Application No: AB/41/20/L

Site Address: Mews House London Road Arundel BN18 9BH

Description of works: Listed building consent for a single story extension at rear of property with roof terrace extending across to existing terrace, shiplap panelled ground floor wall, addition of rendering, alterations to fenestration & new brick garden wall.

OWPC27575

**Existing North elevation
scale 1:100**

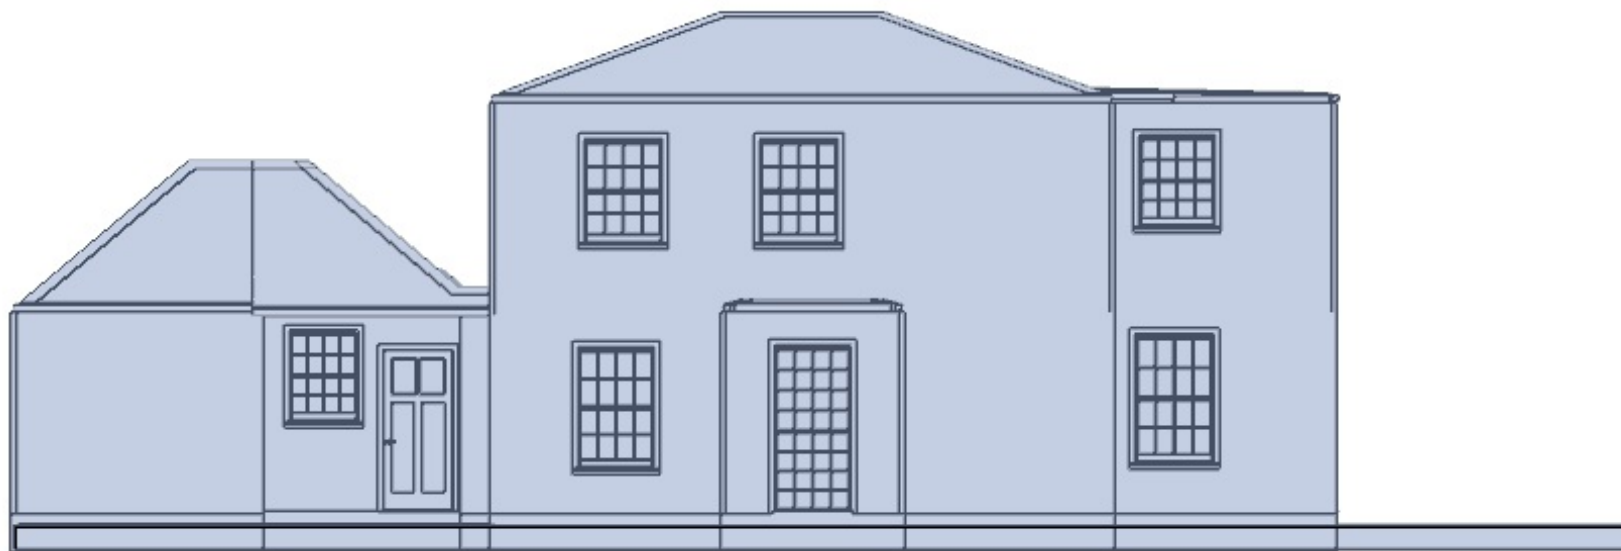
The replacement of the relatively small area of shiplap with suitably coloured render on the street elevation will have no adverse impact on the character or appearance of the conservation area. Neither too will the construction of the garden wall as long as the bricks, mortar and bonding match those on the side elevation of the house.
